SSD 7484 – MODIFICATION 8 RESPONSE TO REQUEST FOR FURTHER INFORMATION 23-33 & 35-39 BRIDGE STREET, SYDNEY – THE SANDSTONE PRECINCT

This Response to Submissions has been prepared by Ethos Urban on behalf of Pontiac Land (Australia) Pty Ltd (Pontiac) to address submissions received during the notification period of a modification application (Mod 8) to State Significant Development 7484 (SSD 7484) which relates to the development of tourist and visitor accommodation at the Sandstone Precinct, Sydney.

DEMOLITION PLANS
LANDS BUILDING - LEVEL 01
EDUCATION BUILDING - GROUND

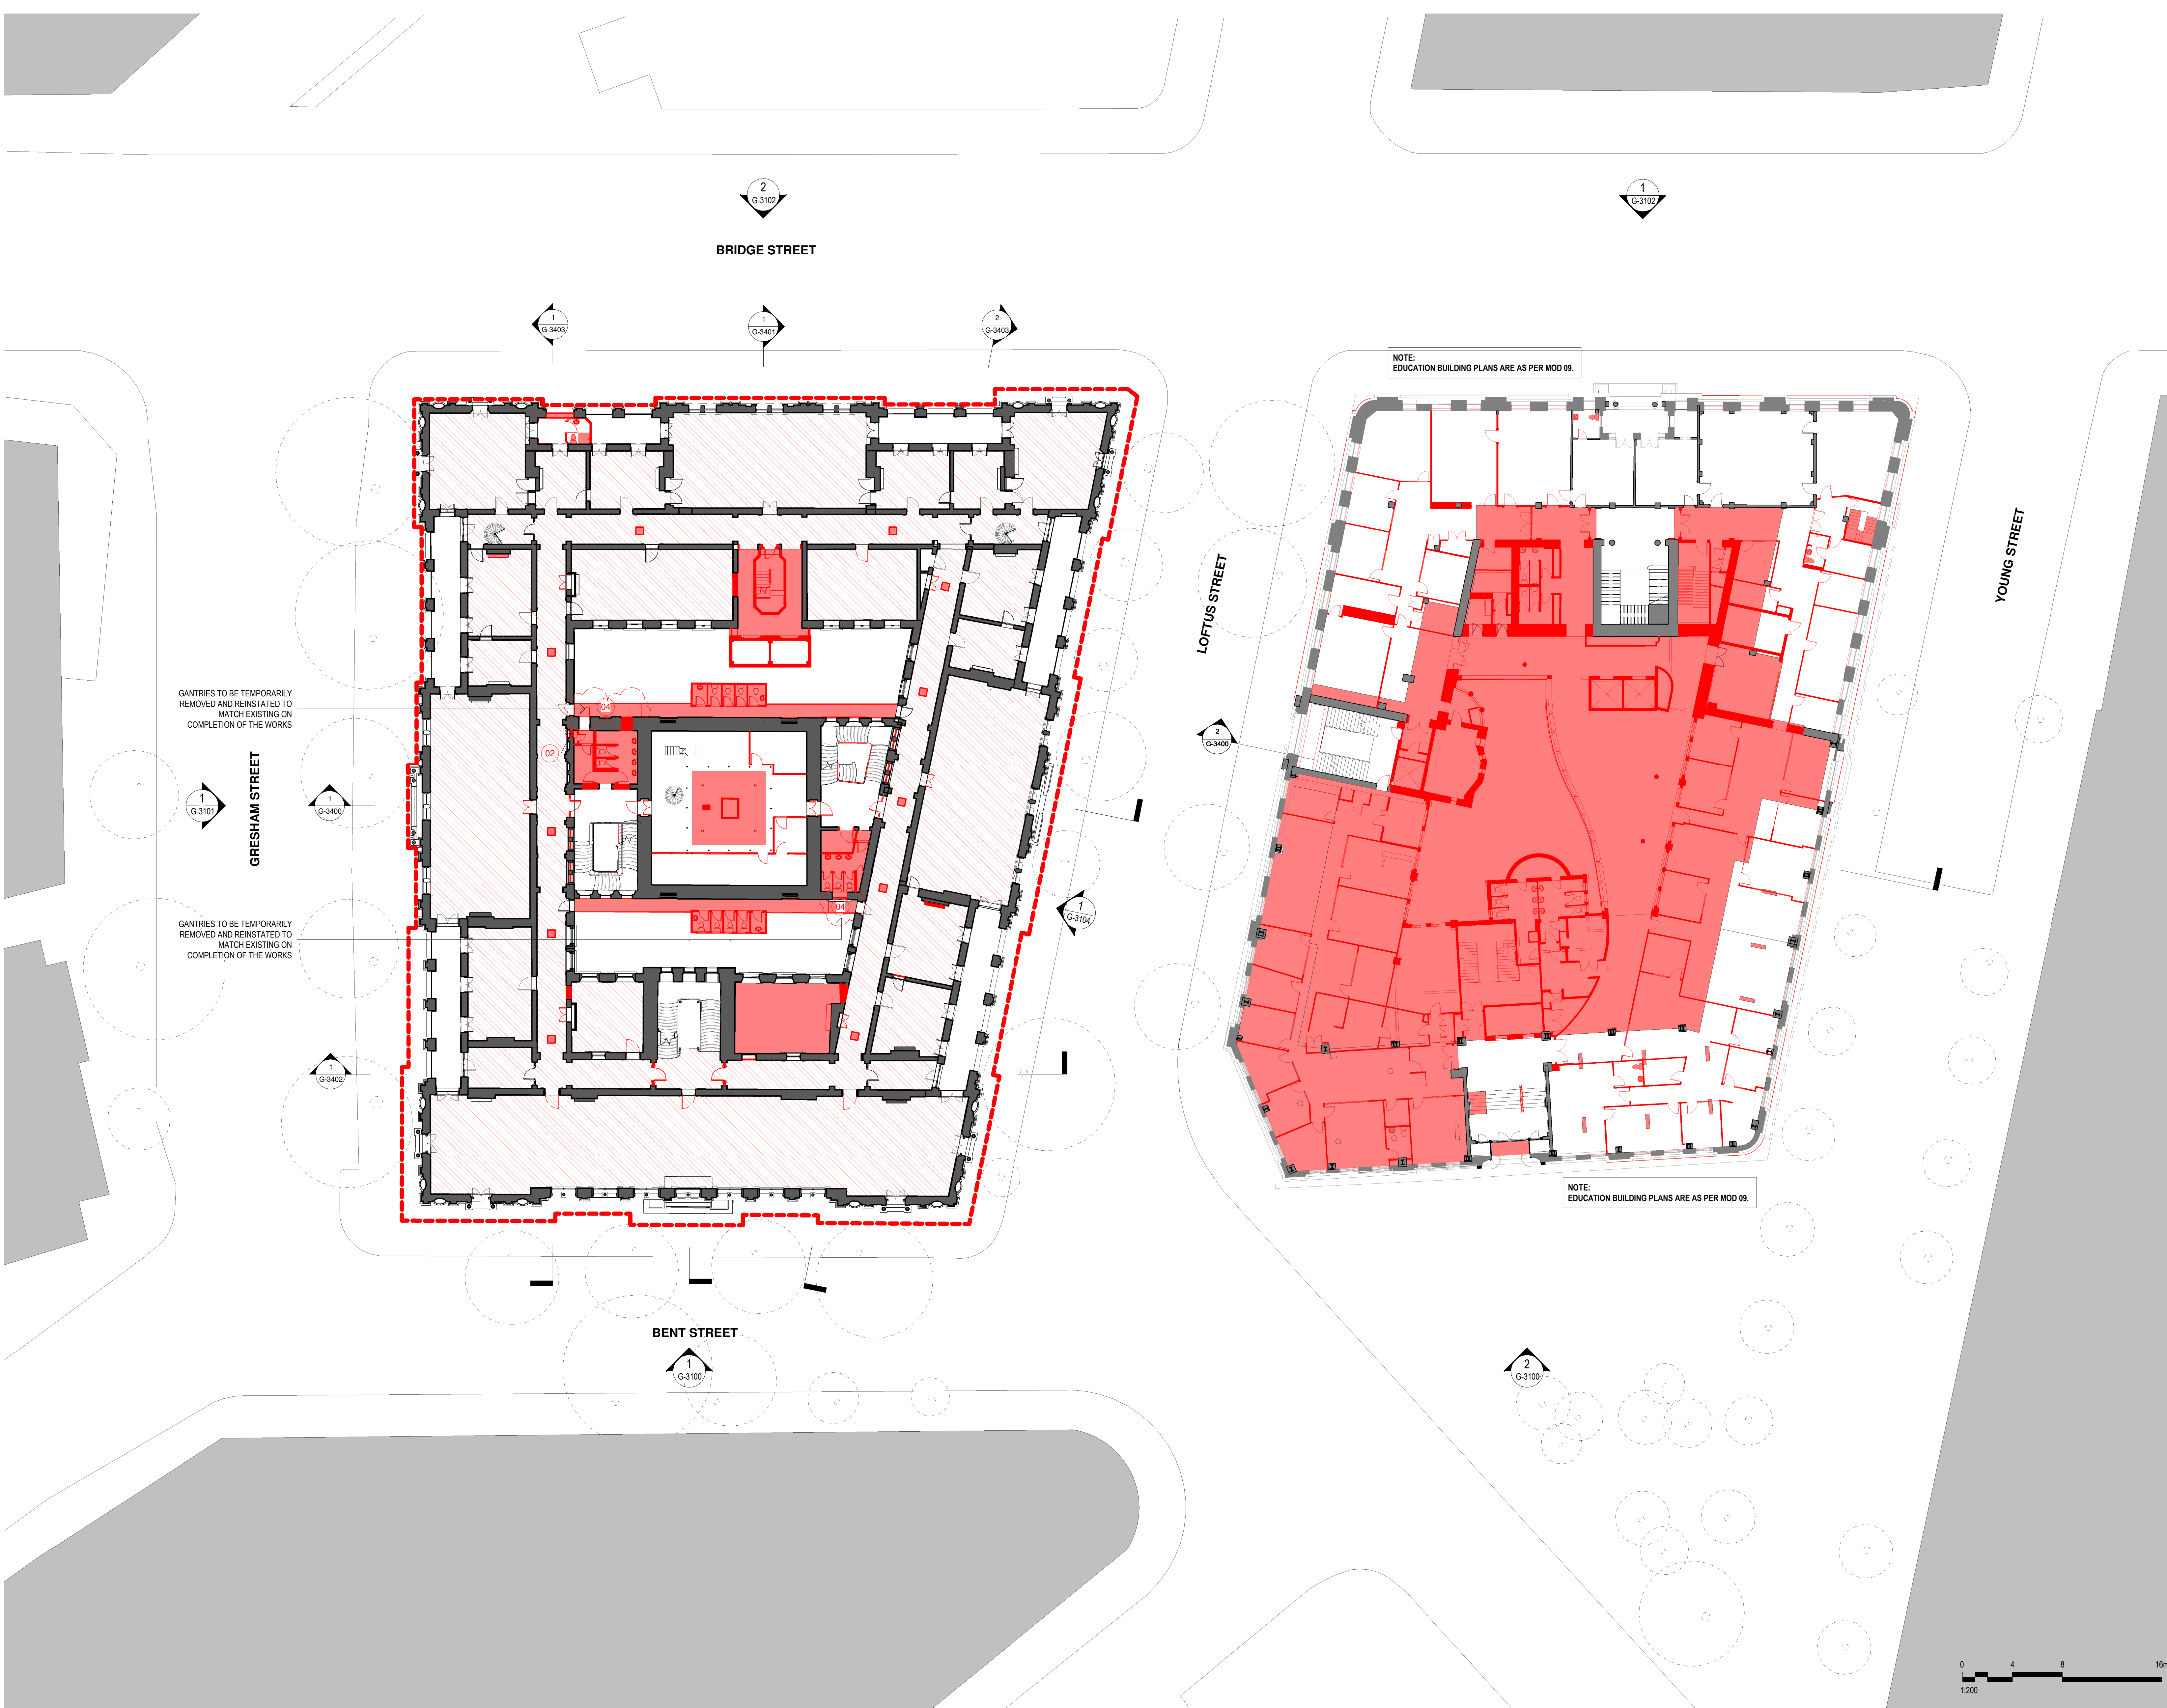
It is unclear if the additional slab demolition at the ground floor level would result in any ground disturbance/excavation outside the area approved by the development consent for SSD-7484. If the Mod 8 proposal were to result in any additional impact the proponent should address how Aboriginal cultural heritage matters will be addressed. A Heritage Impact Assessment (Attachment C) accompanied the application, but it did not address Aboriginal cultural heritage matters.

No additional excavation or ground disturbance will occur as part of the proposed slab demolition as it is situated above ground level (i.e. natural ground level relates to lower ground) and as such no further consideration of Aboriginal cultural heritage matters is required.
